Ribble Valley Borough Council  
Housing & Development Control

Your ref: 3/2023/0540  
Our ref: D3.2023.0540  
Date: 14<sup>th</sup> August 2023

Application no: **3/2023/0540**

Address: **Land off Chapel Hill (Hall Barn Drive) Longridge PR3 2YB**

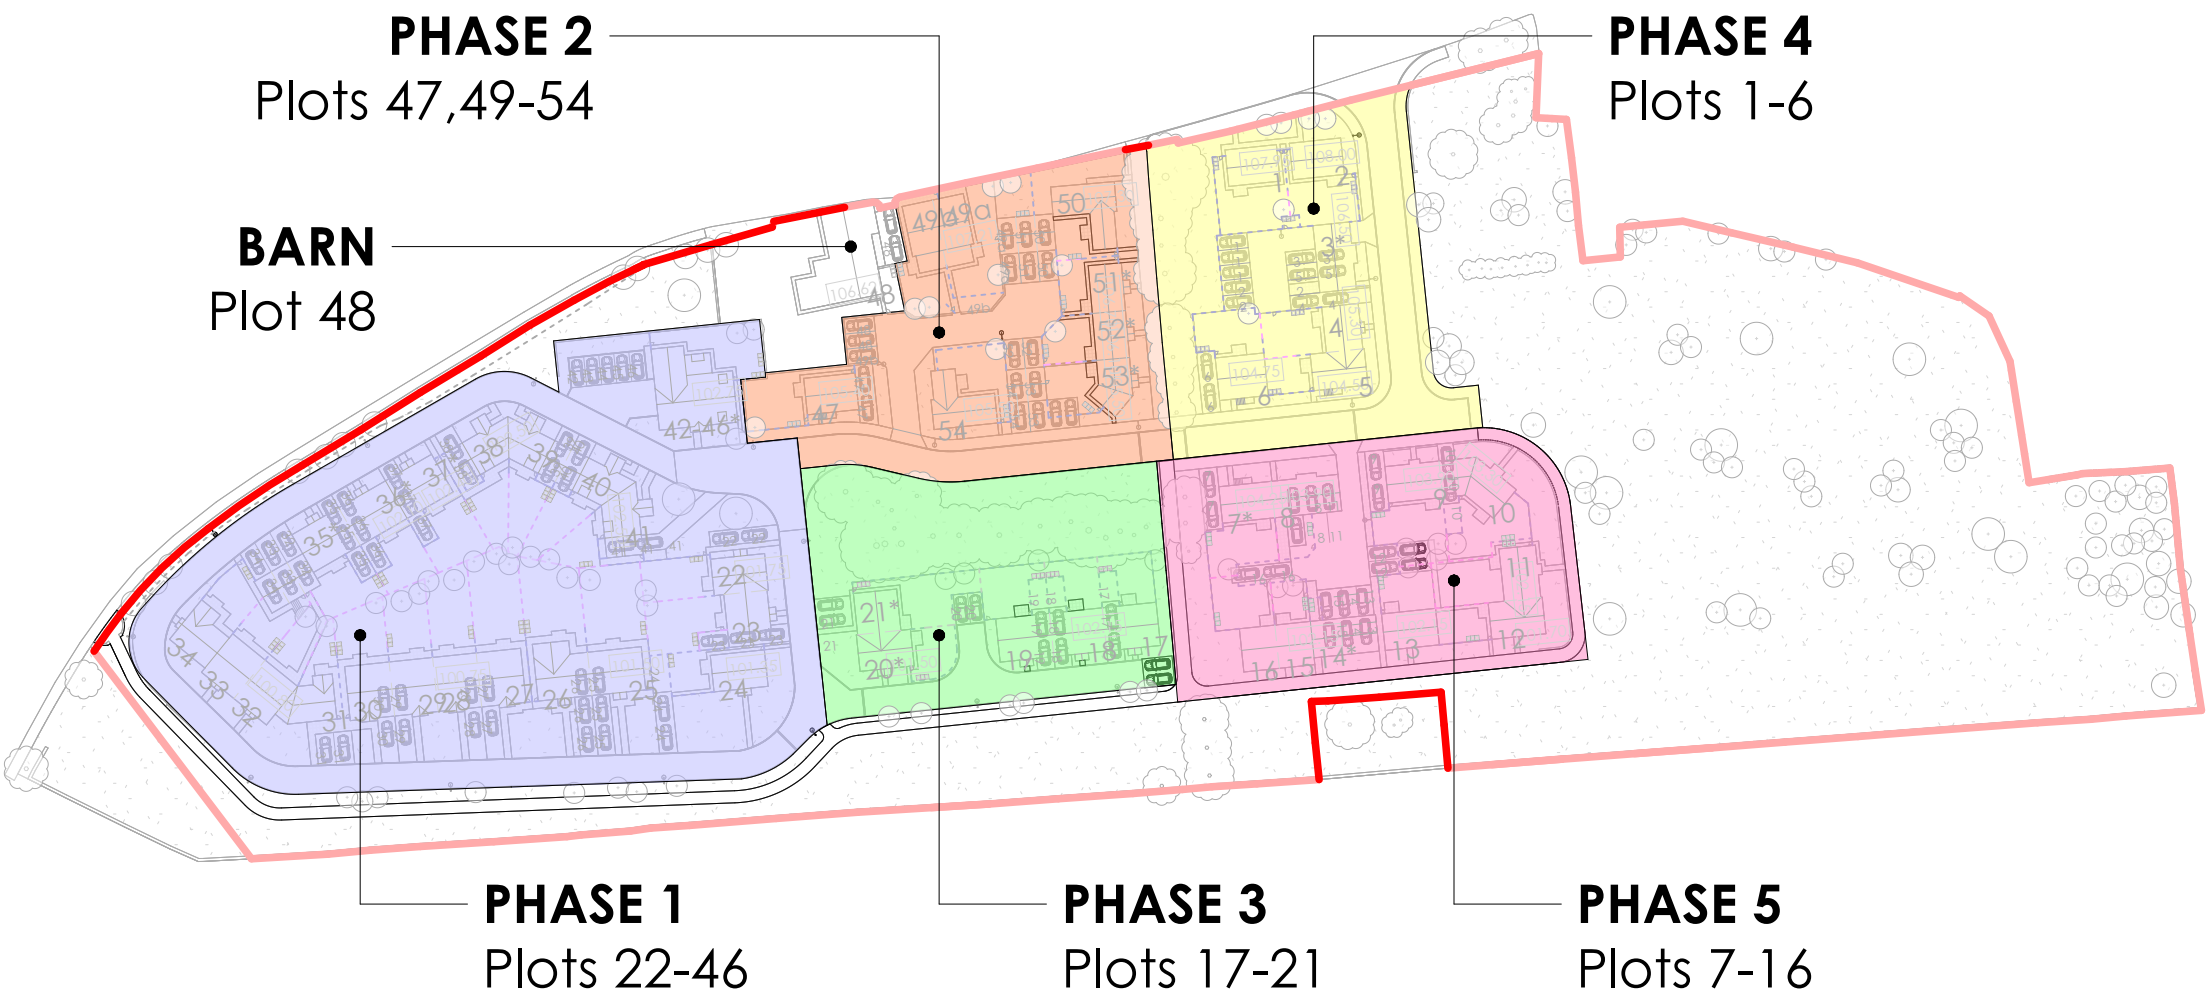
The LHA have reviewed the D2 drawing number CN-00-001 Rev J titled "Master Site Plan" and are aware that the Developer is aiming to remove an internal pedestrian link which connects to Chapel Brow, remove the proposed attenuation basin, alter the approved parking arrangements for the dwellings and realign the estate road.

The LHA have reviewed the drawing and object to the variation condition. This is because firstly, due to the estate road being re-aligned, the LHA require a swept path of a refuse vehicle using the estate road and provided turning areas to see whether they are safe and suitable and allow the refuse vehicle to exit the site in a forward gear.

Secondly, the LHA require the internal pedestrian link to Chapel Brow to still be provided, alike the submitted drawing D2 drawing number CN-00-001 Rev G titled "Master Site Plan," which is shown on the Local Planning Authorities planning portal. The LHA still require the internal pedestrian link to be provided because it connects to Bridleway BW0302058, part of the Public Right of Way network, and will be used for leisure activities by the occupants of the site. Therefore, it is seen as an important asset for the development.

Thirdly, the LHA are aware that the parking arrangements for the dwellings have been altered in response to the changes to the estate road. The LHA have no concerns regarding the quantity of car parking spaces available and the location of the spaces are similar to what have already been approved, via spaces being provided in integral garages or via undercrofts. The LHA do raise a concern, however, regarding one of Plot 50s car parking spaces. This is because one of the Plots spaces is located adjacent to Plot 52 and its garage. The LHA are concerned that the occupants of Plot 52, may believe that the space adjacent to their garage is theirs. Therefore, to prevent any disputes between the occupants of Plot 50 and 52, regarding the car parking space, the LHA advise that the space for Plot 50 is relocated closer to the Plot.
